Our ref: DOC20/90193

Response to Submission comments for Glebe Island Concrete Batching Plant and Aggregate Handling Facility (SSD 8544)

Heritage NSW

Figure 15 Area of identified archaeological potential (shown in red) associated with the alignment of the first Glebe Island Bridge

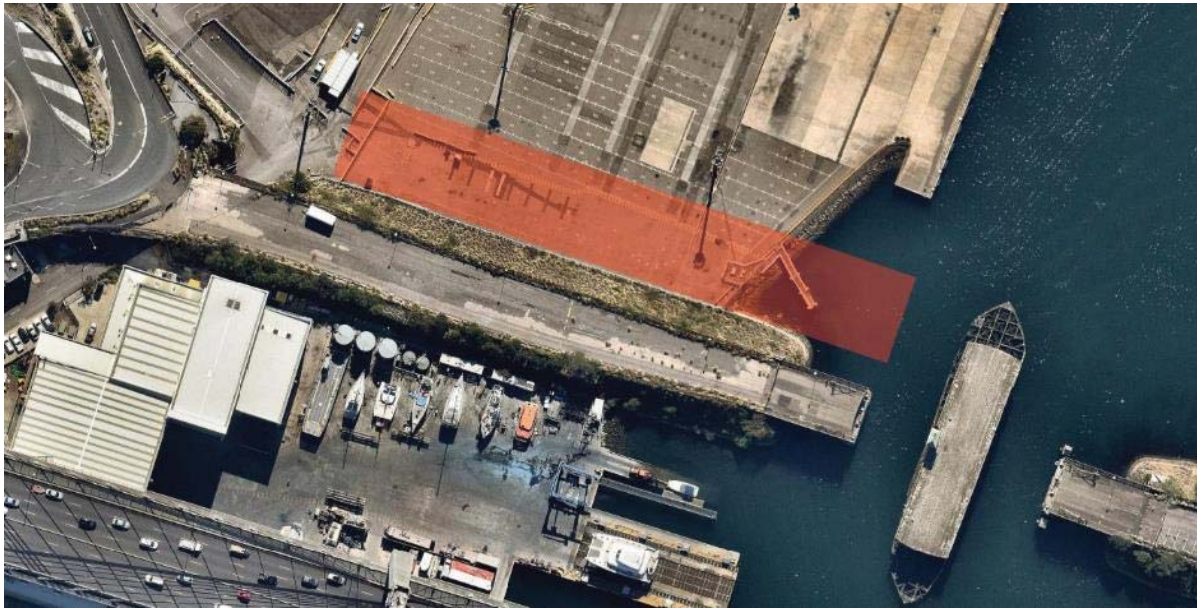
The Statement of Heritage Impact (SOHI) has identified there is the potential for significant archaeology to be present in the form of bridge piles and other structural remains associated with the first Glebe Island Bridge (1862). As this is an SSD project approval under the *Heritage Act 1977* is not required. However, the consultant has recommended a monitoring program be implemented and has provided an Archaeological Research Design and Methodology. Although the former bridge piles would not be a relic within the meaning of the Heritage Act, due to the high level of research potential being identified, the approach to monitoring is supported.

- a) A historical archaeological monitoring program be undertaken concurrently with any excavation works below the existing hardstand in the vicinity of the proposed silo area.
- b) The approved Research Design and Methodology which outlines the methods for the archaeological monitoring, recording procedure of any remains or relics that are uncovered, and research questions and reporting requirements.
- c) The archaeological monitoring works be undertaken by a suitably qualified historical archaeologist under the approved Research Design and Methodology document, and the document included in any project detailed construction program.
- d) At the conclusion of the work a report of the findings from the monitoring program be prepared and submitted to Heritage NSW with 12 months.
